**RE: Smiles for Kids Dental Office – Site Expansion**  
**Conceptual Grading and Drainage Plan**  
**Stamp Date: 02/21/18**  
**Hydrology File: C12D056**

Based upon the information provided in your submittal received 02/22/2018, the Conceptual Grading and Drainage Plan **is not** approved for Site Plan for Building Permit. The following comments need to be addressed for approval of the above referenced project:

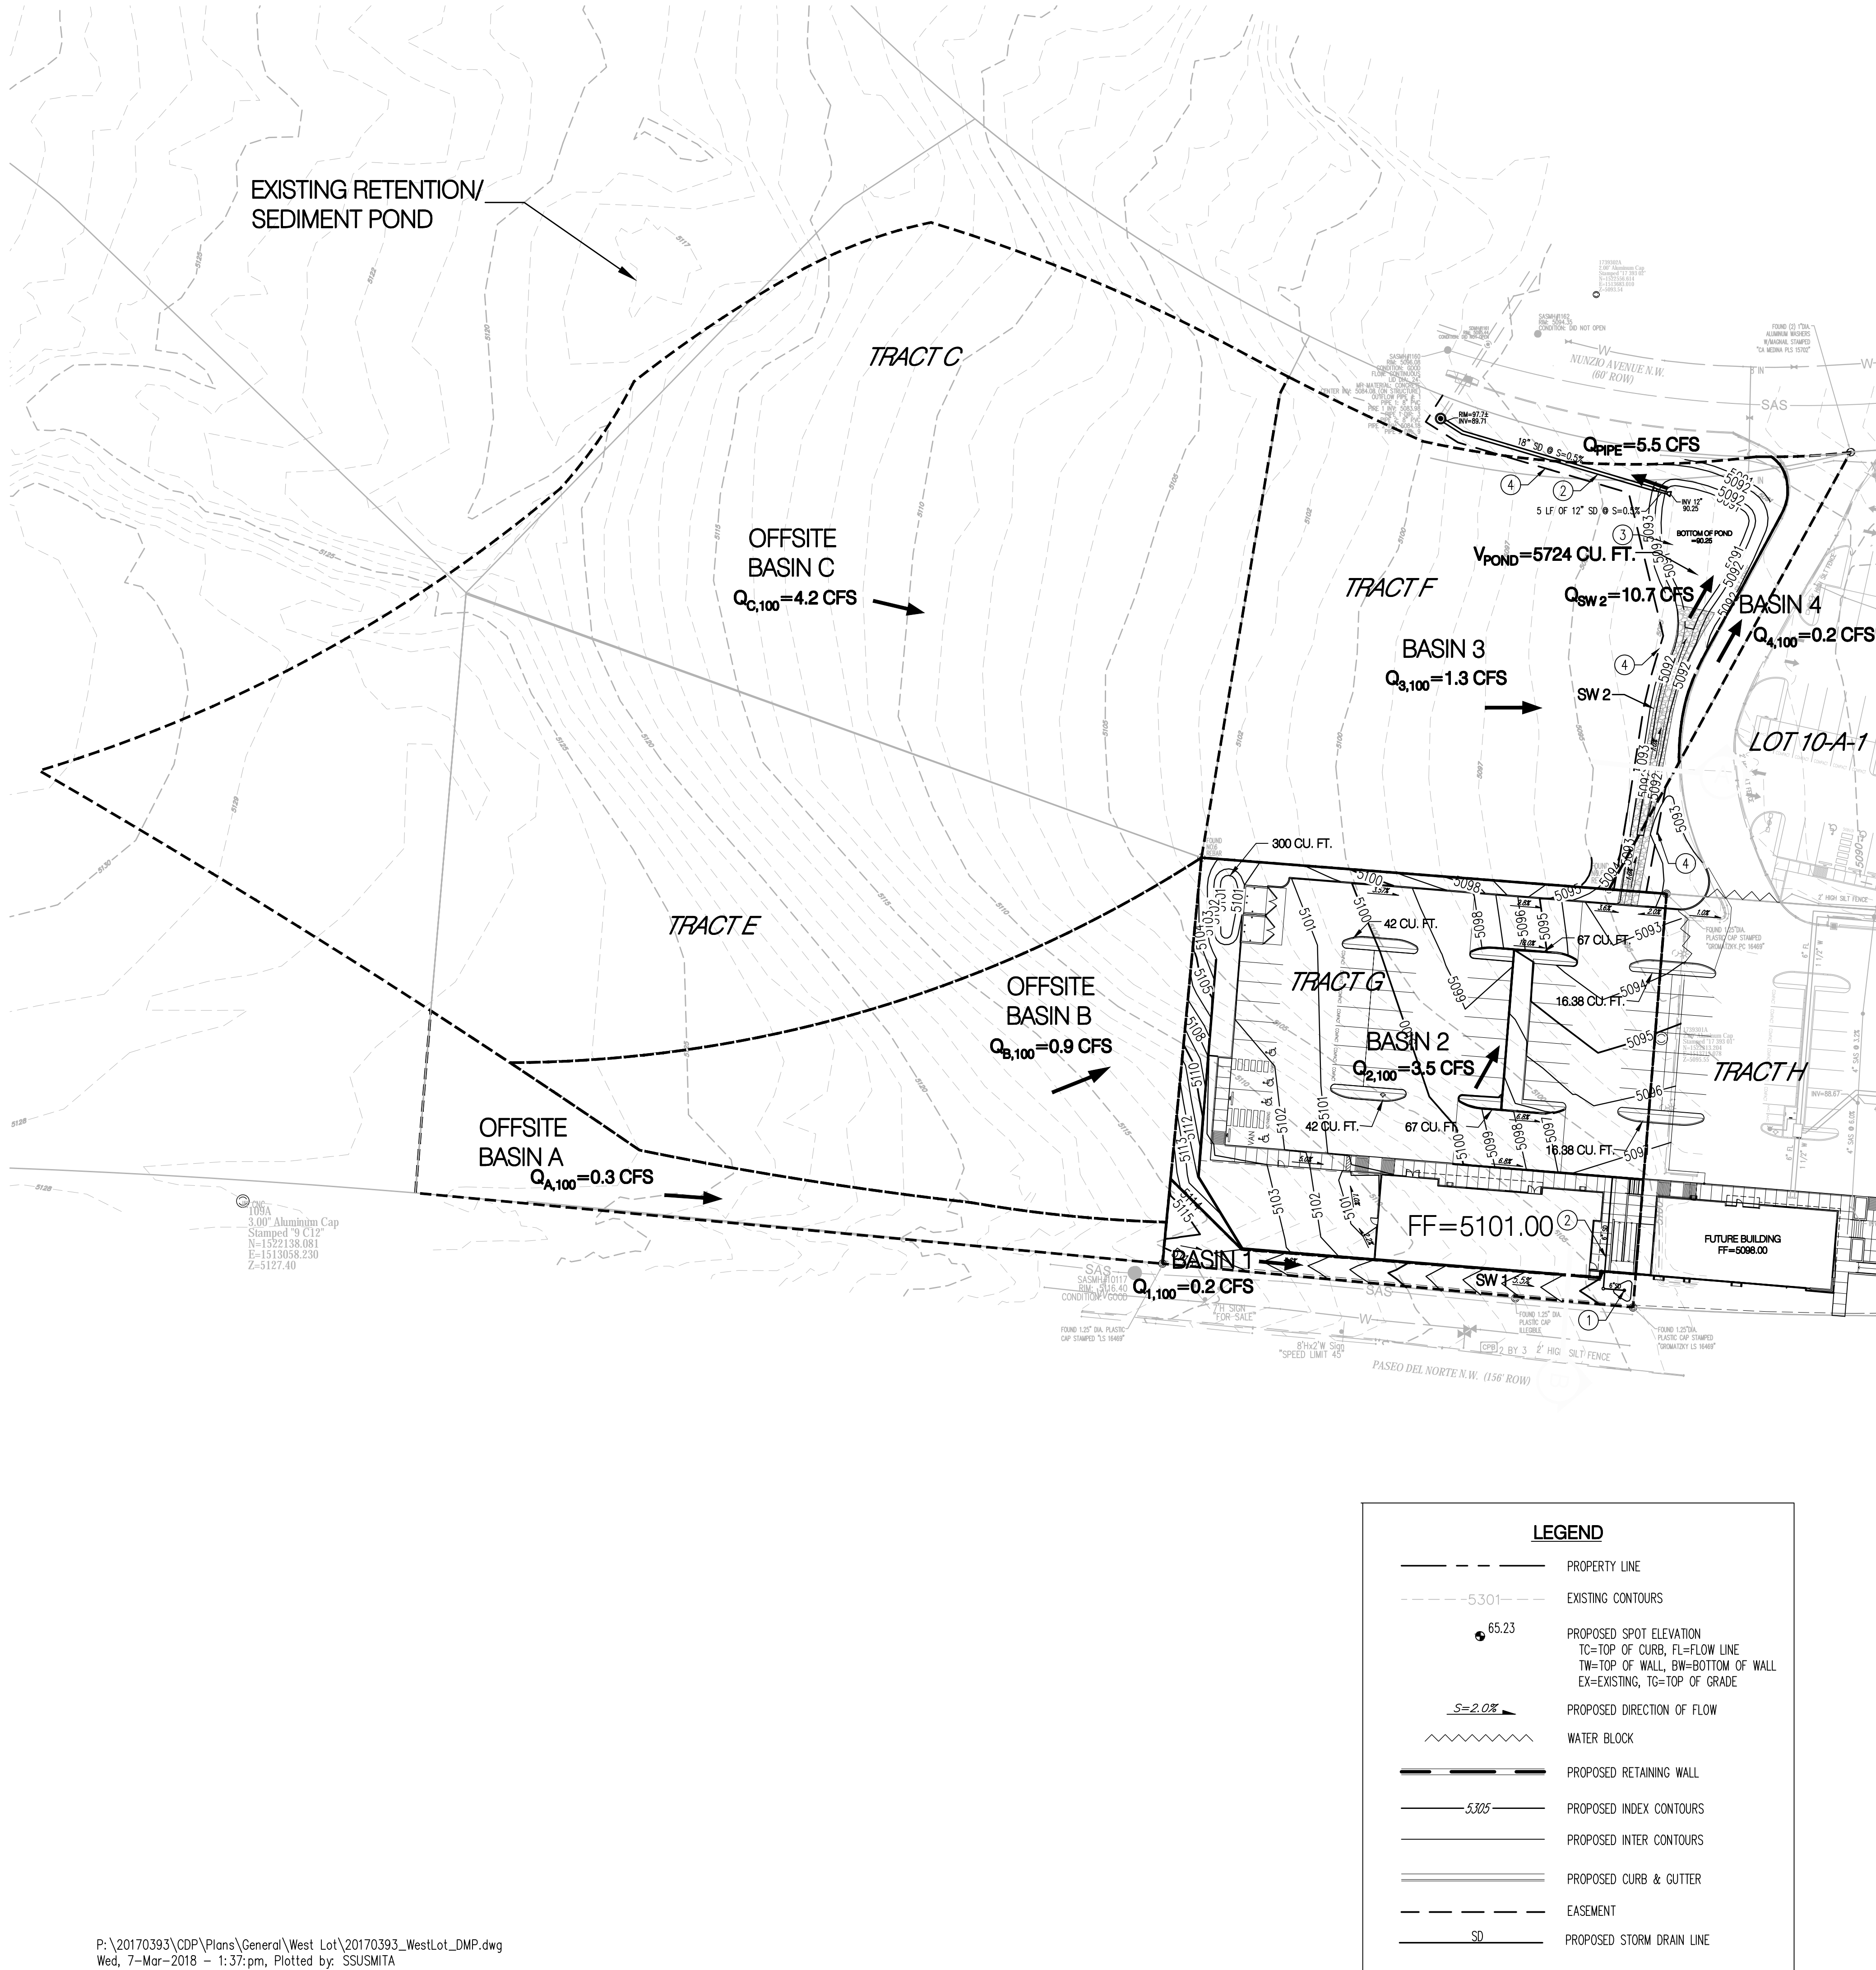
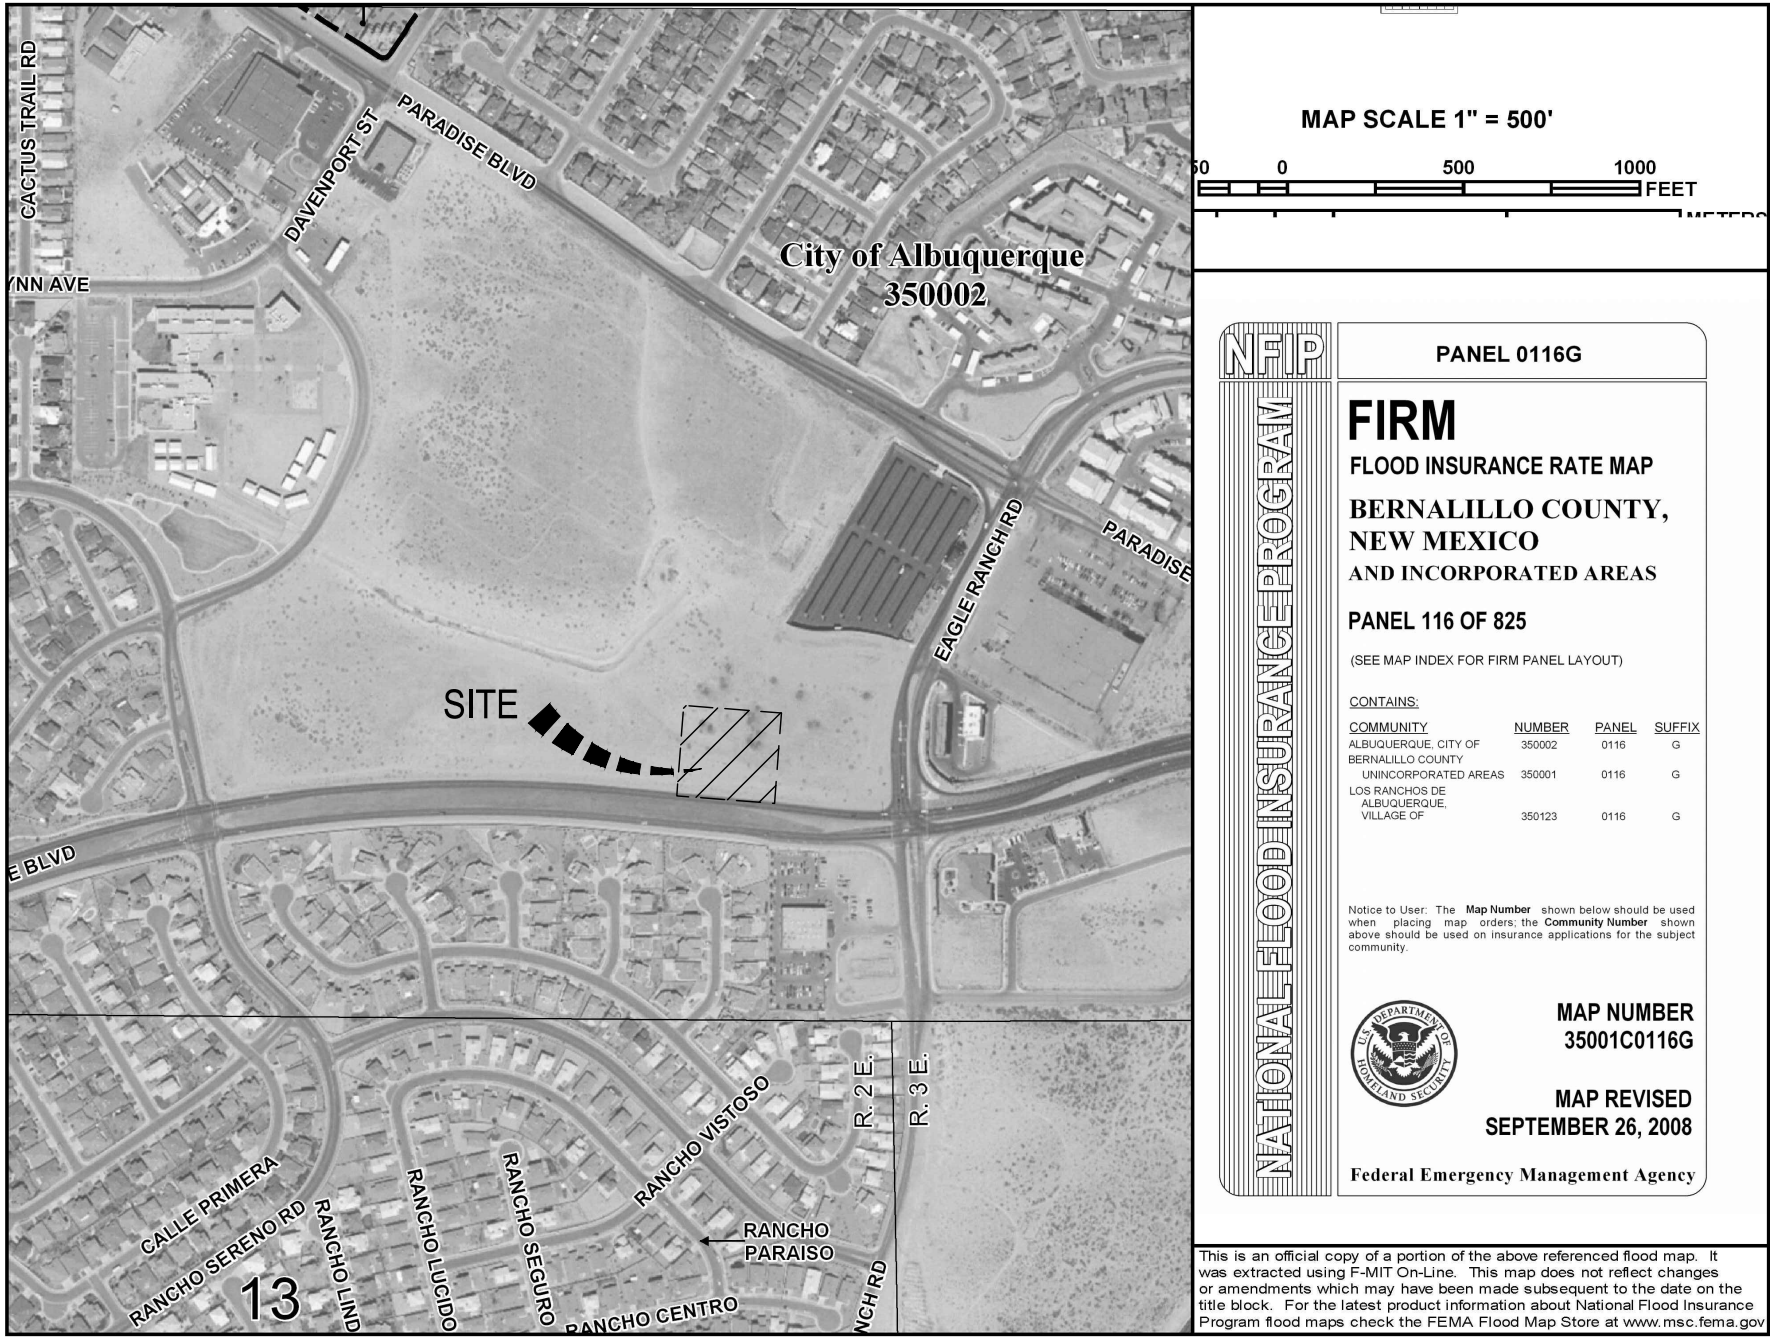
1. Please show and label the existing information within the ROW of Nunzio Ave (extend the ROW information past Tract C) on both Sheets C001 & C101. This can be taken from the latest aerial (Google Earth).

2. Please show a private drainage easement along the proposed Swale, detention pond, and the segment of the private storm pipe on Sheet C001, C100, & C101.

3. Please label Tract H and Lot 10-A-1 on Sheet C001.

4. Please correct the flow arrow on Drainage Areas for Basin 3 & Off-site Basin C on Sheet C001.
